Make Planning Appeal

Planning authority	Kildare County Council
Planning authority register reference number	25/61119
Address of proposed development	Lands at Railpark Maynooth Kildare Ireland

Re: Appeal Submission Regarding Proposed Development Adjacent to Rockfield, Railpark,
Maynooth

Planning Reference No: 25/61119

Figure 3.1: Western Boundary Treatment Drawing

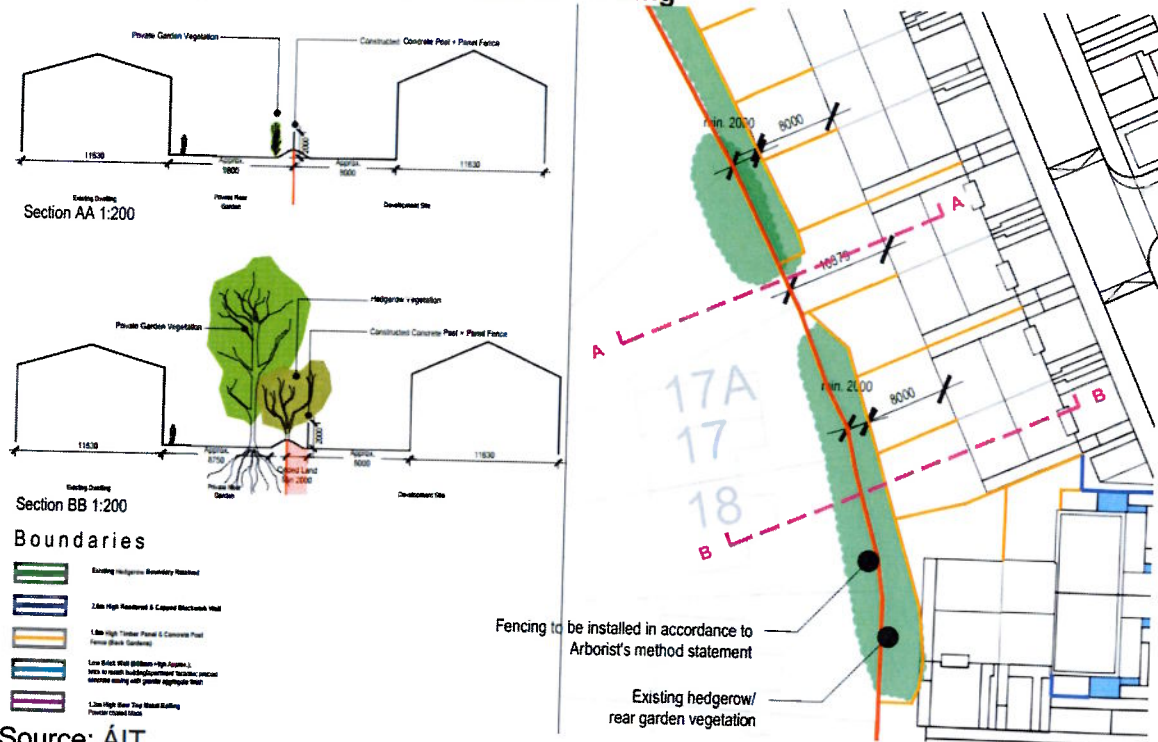
The proposal to install a weld mesh (Hercules-type) fence in place of a solid boundary wall is inappropriate where existing family homes directly adjoin the development.

- Does not adequately protect privacy, particularly for children
- Permits direct overlooking into rear gardens
- Fails to contain vegetation or prevent encroachment
- Offers limited security
- Encourages litter accumulation and facilitates anti-social access

A solid boundary wall of suitable height and finish is necessary to:

- Safeguard residential privacy
- Provide a durable and secure separation
- Prevent scrub and invasive plant growth
- Support long-term maintenance of the estate
- Reduce vermin movement between sites
- Eliminate ambiguity regarding boundary ownership and responsibility

Figure 3.7: Extract of Layout illustrating 'cul de sac'

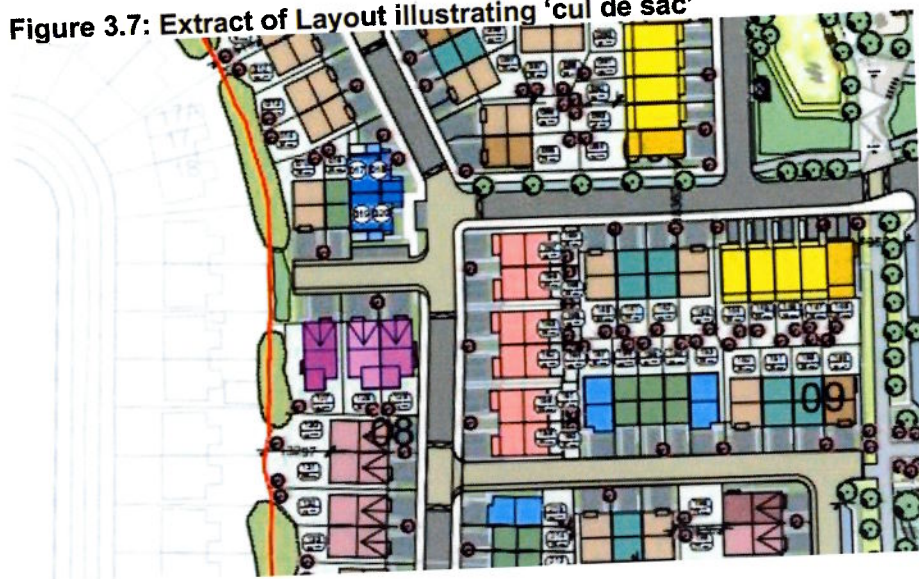
The proposed cul-de-sac to the rear of existing properties raises significant concerns.

The inclusion of a roadway and turning area in this location increases the risk of:

- Overlooking of private gardens
- Loitering and gathering
- Noise disturbance
- Unauthorised access to rear properties

This layout is inconsistent with established residential design principles and fails to adequately protect the amenity of current residents.

Figure 3.9: Separation Distance with Rockfield Green

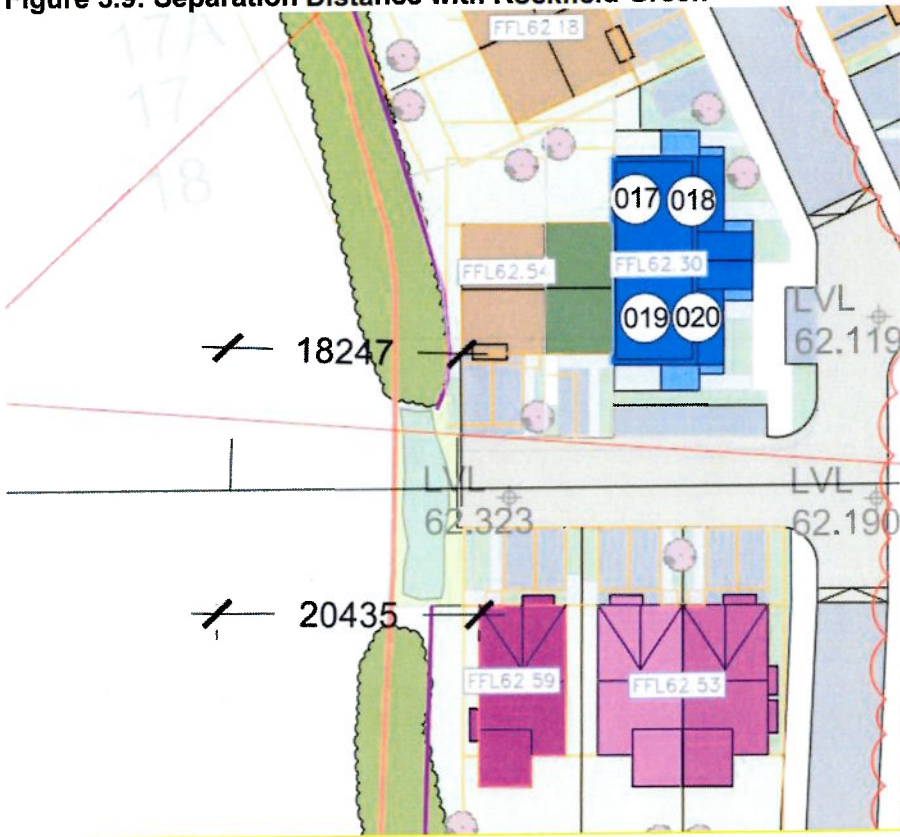
The layout appears to introduce narrow, undefined strips of land between existing rear boundaries and the proposed development.

- Illegal dumping
- Anti-social behaviour
- Overgrowth and ongoing maintenance issues
- Reduced security
- Uncertainty regarding responsibility for trees and storm damage

These residual spaces should be eliminated through redesign or incorporated into clearly defined plots (folios) with explicit ownership and maintenance responsibilities.

- Adequate rear garden separation distances
- Natural passive surveillance
- No overlooking or intrusive elements such as balconies
